Application no: **3/2022/0222**

Address: **Land off Lincoln Way Clitheroe BB7 1QD**

Proposal: **Proposed new building to provide car wash area and undercover car storage area for vehicles awaiting collection. Closure of existing vehicular access and creation of new car park access. Resubmission of 3/2021/0398.**

The Local Highway Authority have viewed the plans and highway related documents and have the following comments to make:

PROPOSED SITE PLAN

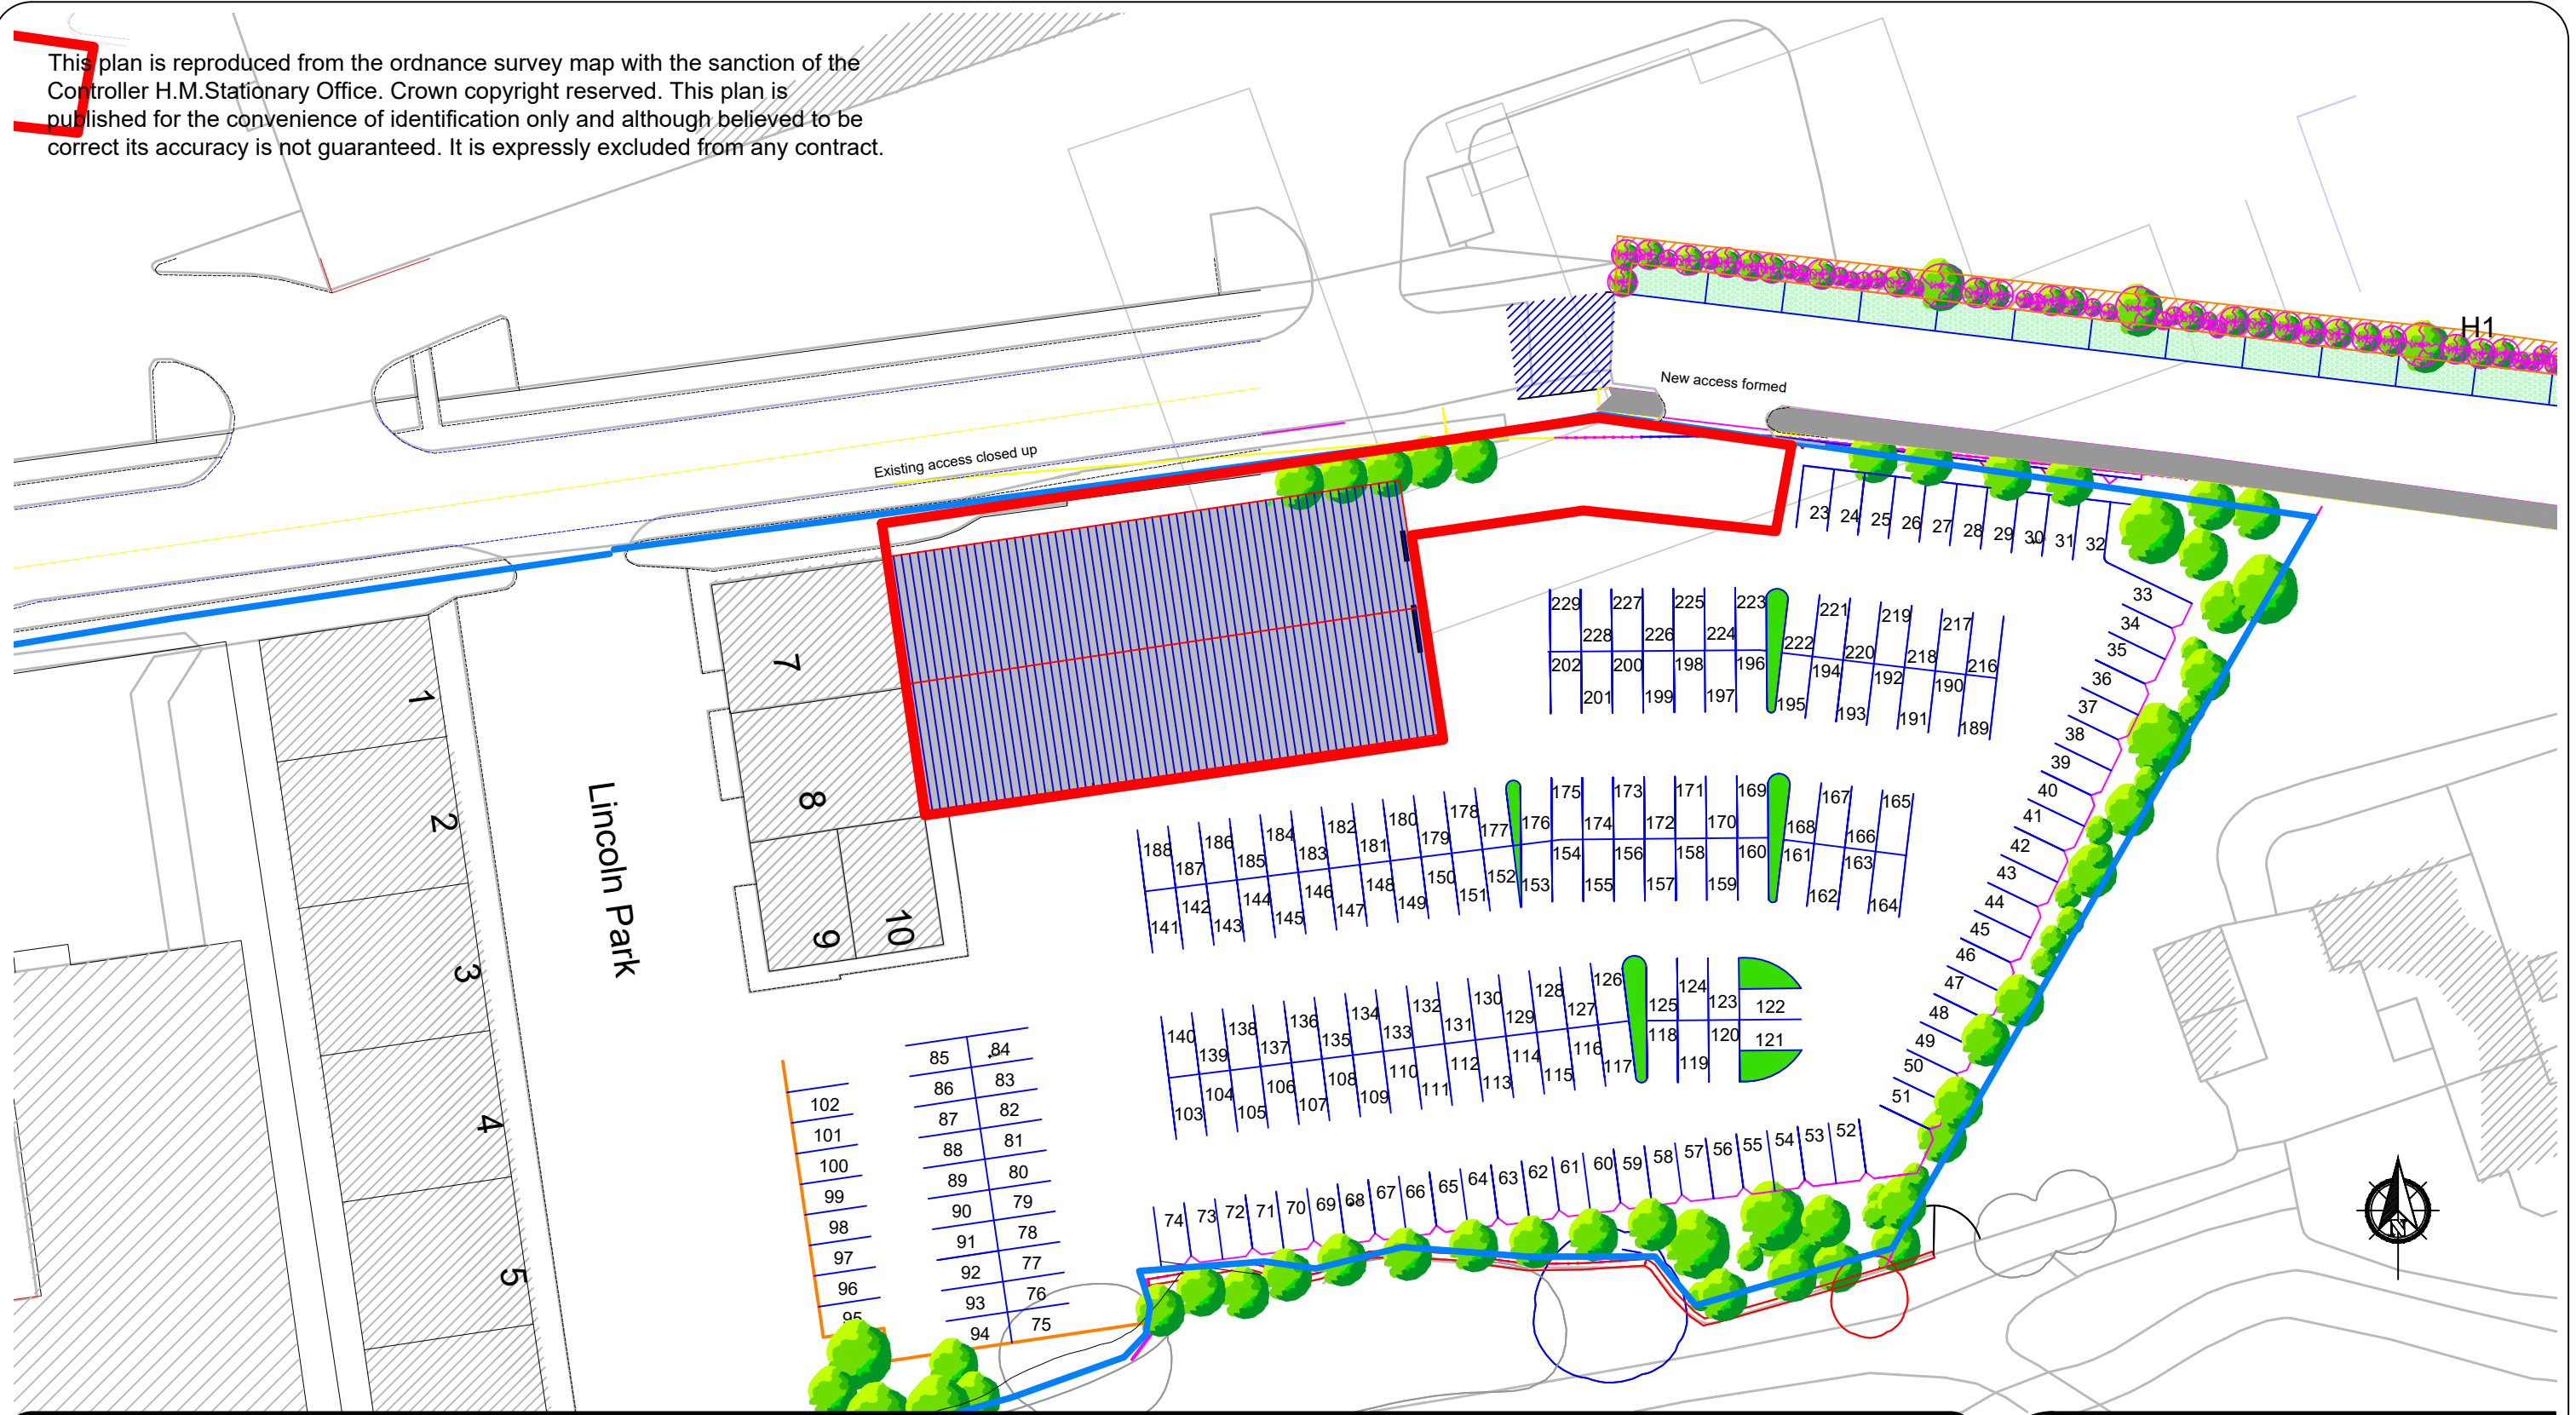
To erect the new building which will be adjoined to Unit 7 and 8, as shown on Avalon drawing number ALPD/22- Dwg 03 titled "Proposed Site Plan", will conflict with the existing access to the car park which serves Lincoln Park Industrial Site.

The LHA do advise the Applicant that the existing access should be stopped up with full height kerbs and the existing footway should be extended to make the area complete.

The LHA have reviewed Avalon drawing number ALPD/22- Dwg 03 titled "Proposed Site Plan", and are aware that 9 car parking spaces will be lost at the car park which is shared by the units at Lincoln Park Industrial Site, meaning that 229 spaces will remain.

Usually, the LHA would request that a parking survey is undertaken to determine whether the loss of 9 spaces for the industrial site would cause further on-street parking to occur.

However, given that the site is accessed via an unadopted, private road, a significant distance away from the adopted highway and that the proposal is more an extension rather than an expansion and so the business is unlikely to generate additional traffic and further demand for parking, the LHA have no objection to the proposal.

1. No part of the development hereby permitted shall be occupied until such time as the access arrangements shown on on Avalon drawing number ALPD/22- Dwg 03 have been implemented in full.

2. The development hereby permitted shall not be occupied until such time as the parking and turning facilities have been implemented in accordance with on Avalon drawing number ALPD/22- Dwg 03. Thereafter the onsite parking provision shall be so maintained in perpetuity.
